Consultation Response
KC Landscape – revised due to change in unit numbers and layout
Planning Number: 2020/93954
Proposal: Erection of 43 (Oct 2022) [previously 57] dwellings and associated works, Land at, Lingards Road, Slaithwaite, Huddersfield, HD7 5HY
Date Responded: 31.10.22
Responding Officer: EM
Site Area (Hectares) 2.31ha
Responding Ref: JJ97
DEVELOPER/APPLICANT/AGENT: William Best RIBA
NOTES/COMMENTS:
Landscape Context and Concept, Landscape Design

Landscape Ref: JJ97

SEMI-NATURAL OPEN SPACE

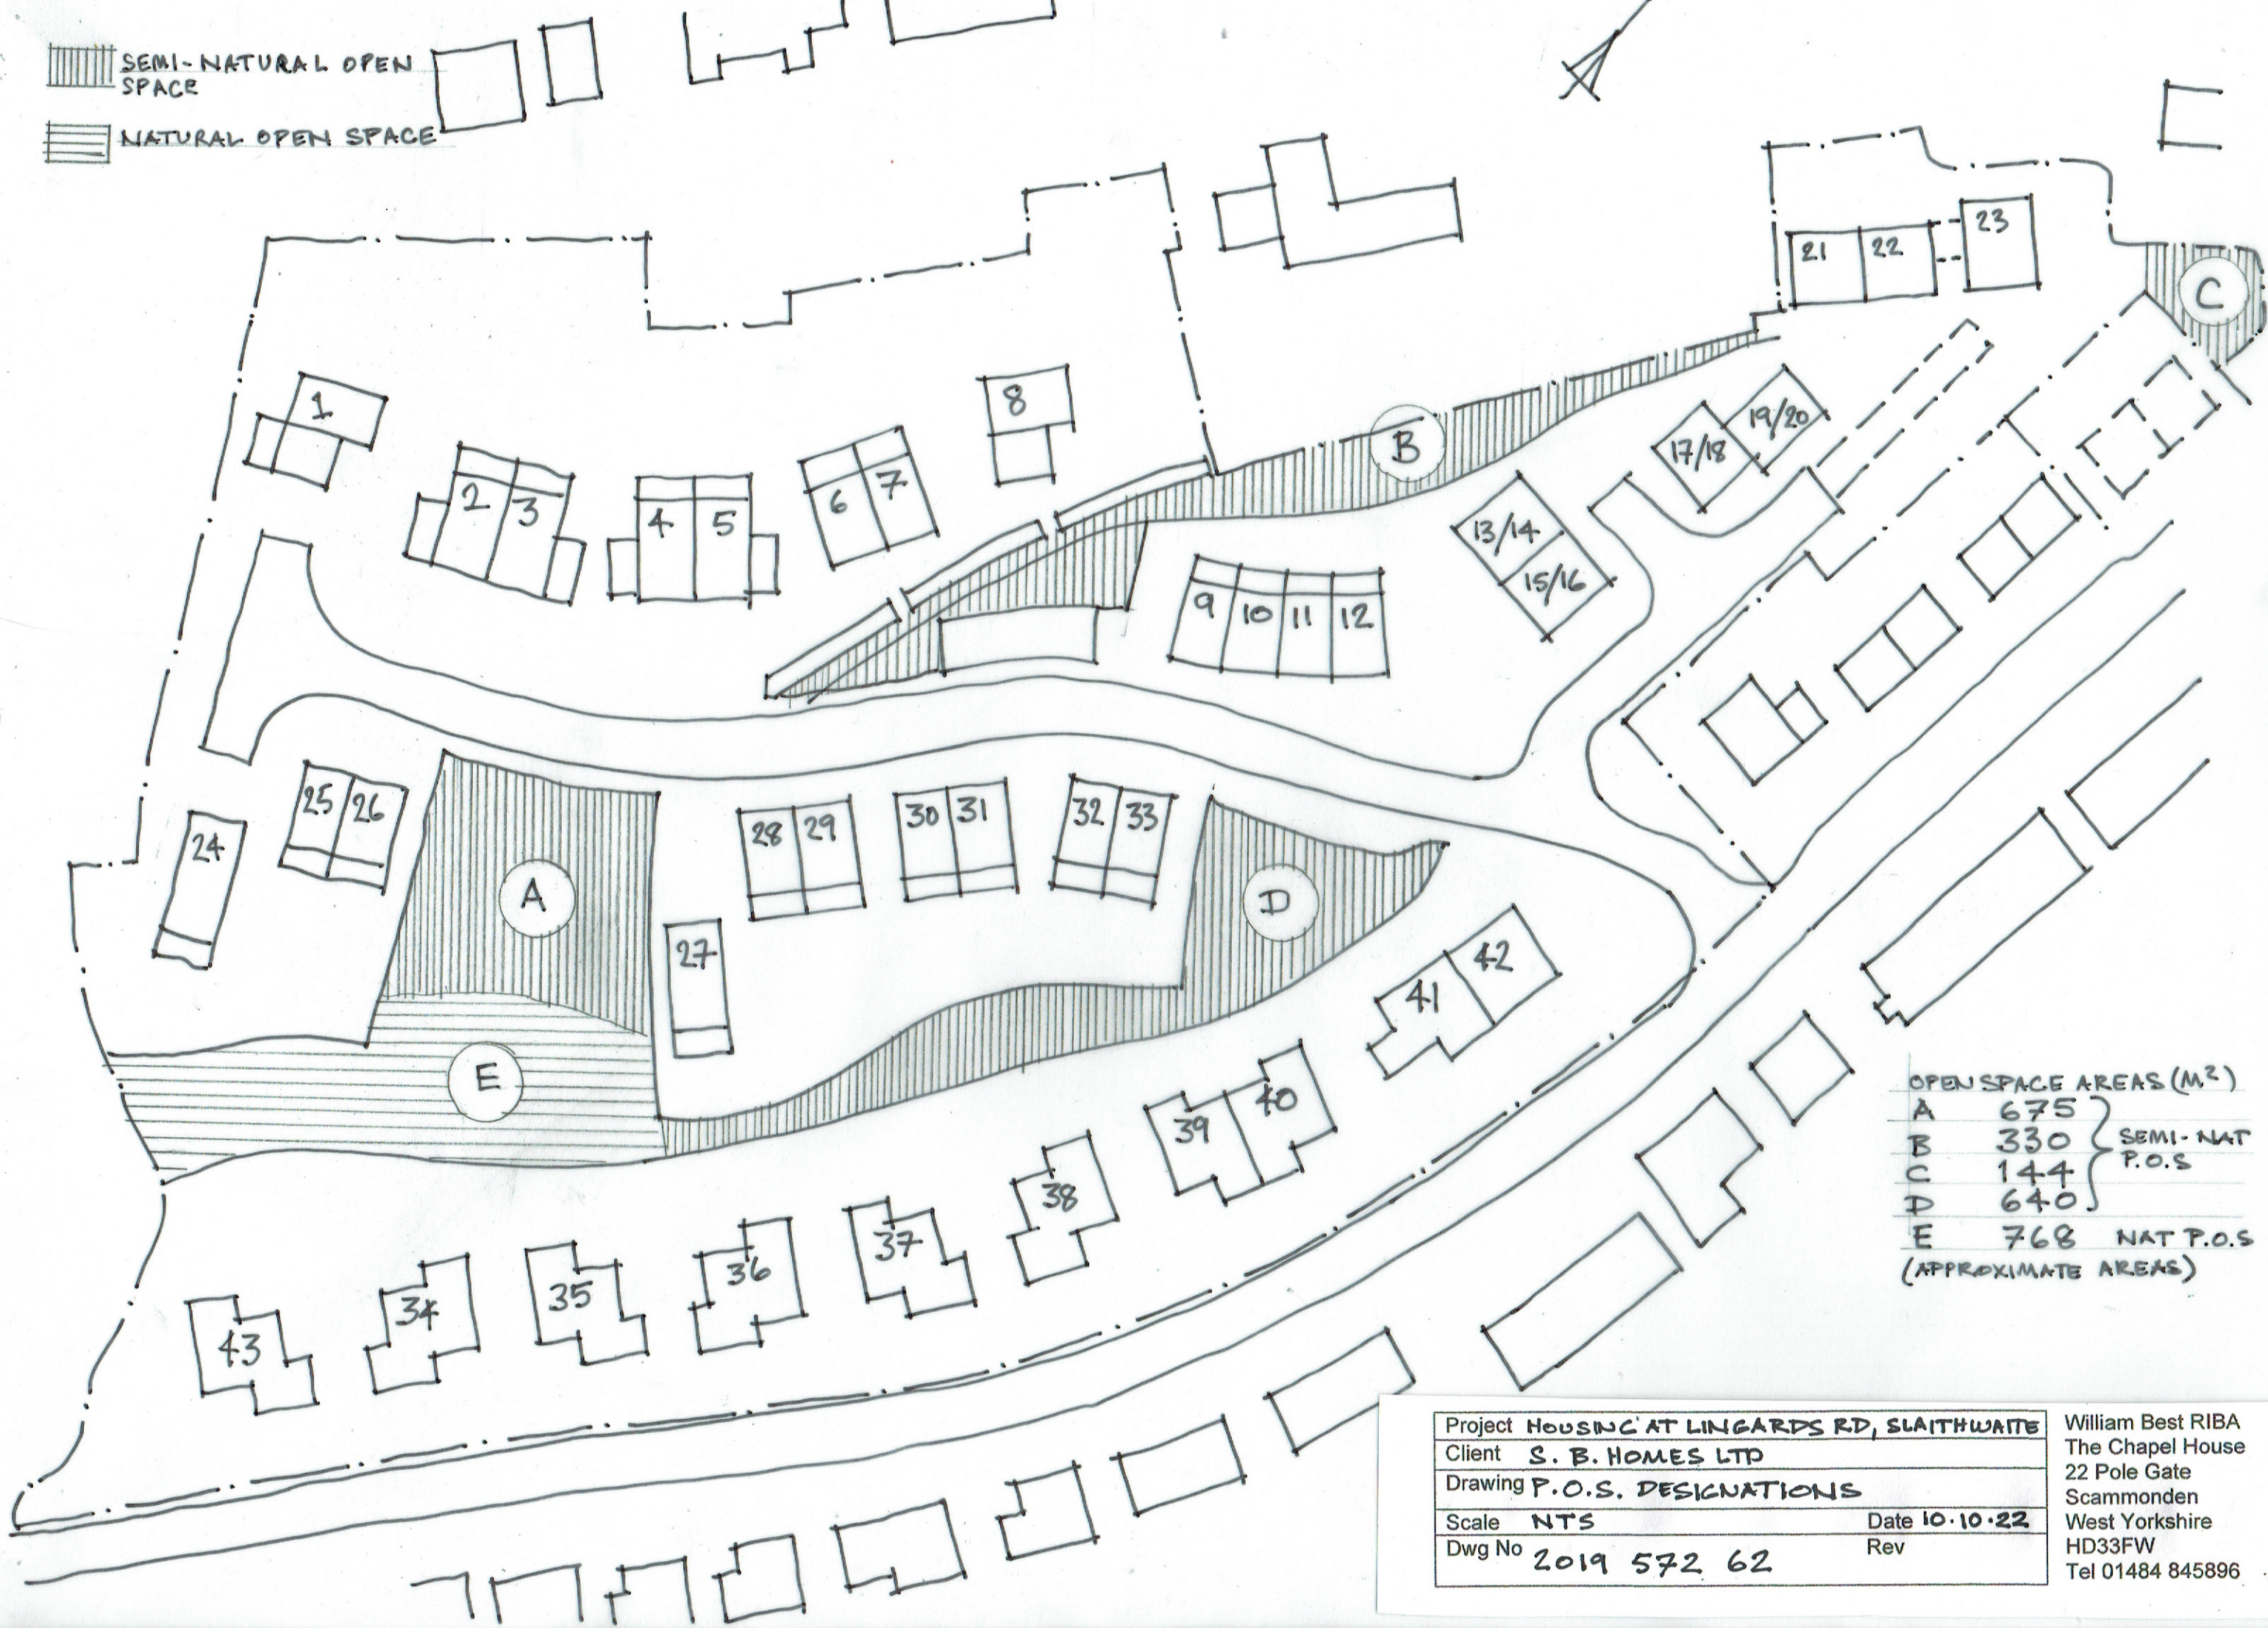
Onsite provision has been set out to a certain extent on the POS designations plan ref Dwg no. 2019-572-62) as 2557 sq.m. Looking at the landscape masterplan provided by FDA, (R/2646/1A) the public open space areas for LP63 are largely a mixture of amenity greenspace and natural and semi natural tree planting on the slopes and this is appropriate for the topography and location. The pos calcs have therefore used these landscape features to determine and allocate the typologies as set out below. In lieu of the full 4991.66.sq.m. being provided on site, we would anticipate an offsite lump sum, Without Prejudice, in the region of £59,632.
